Application for a non-material amendment following a grant of planning permission.

Number	
Suffix	
Property name	
Address line 1	Salt Box Field
Address line 2	Land off Rowan Way
Address line 3	Bersted
Town/city	Bognor Regis
Postcode	PO22 9NW
Description of site location must be completed if postcode is not known:	
Easting (x)	493734
Northing (y)	101717
Description

Hybrid application comprising of Outline application for the principle of employment uses B1-B8. Full application for Class B8 warehouse with fuel-island and car parking (Unit 2), 2 No. Class B1/B8 employment units with associated parking and servicing (Units 6 and 7), Class A1 retail food store with car parking and servicing (Unit 8), 2 No. drive thru units with car parking and servicing (Units 4 and 5), car showroom, workshops (including MOT testing), vehicle storage, external display areas, service areas and parking (Unit 9) together with access roads, associated ground and engineering works, landscaping and ancillary works.

Due to changes in the internal layout of Unit 8 (A1 Food store), within the Full application, 2 windows and a door on the rear (west) elevation have had to move to suit.

WEST ELEVATION

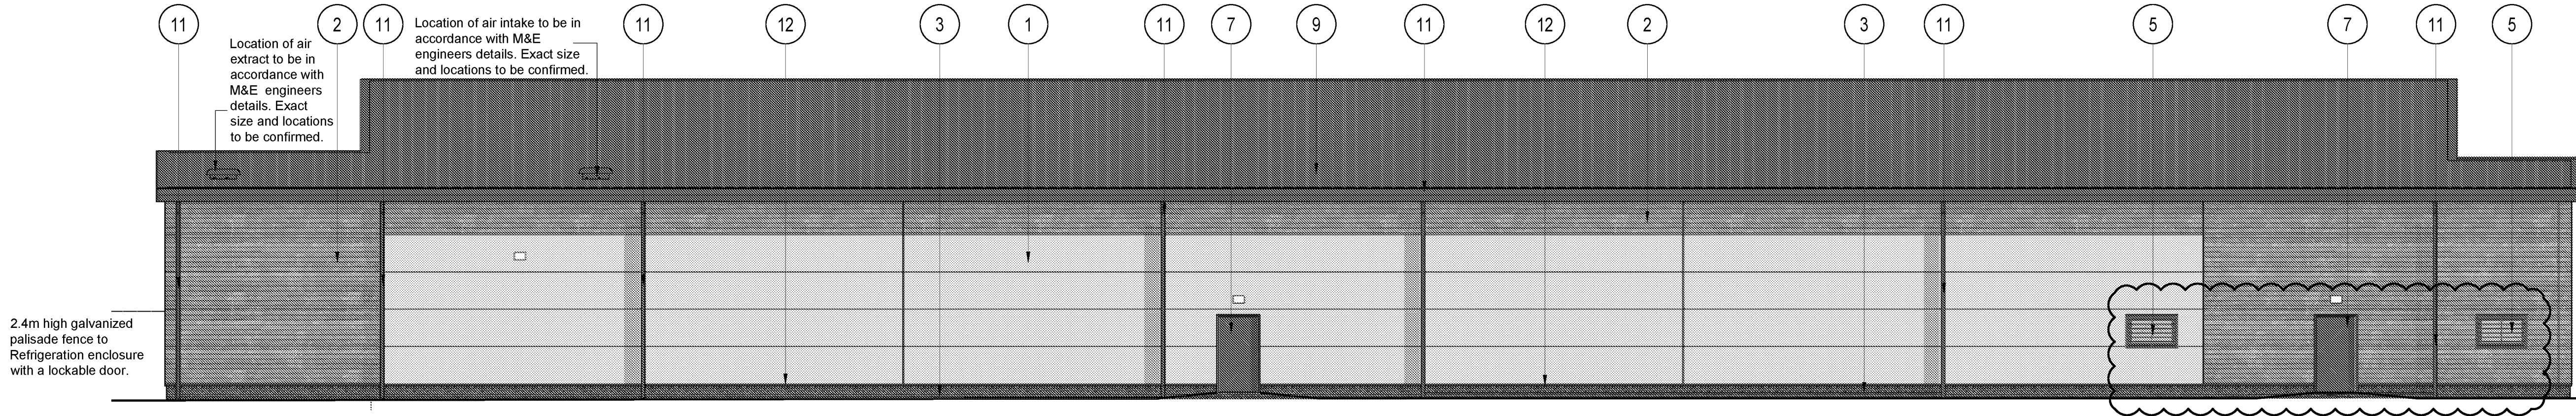
This amendment is as the result of tenant changes to their amenity area
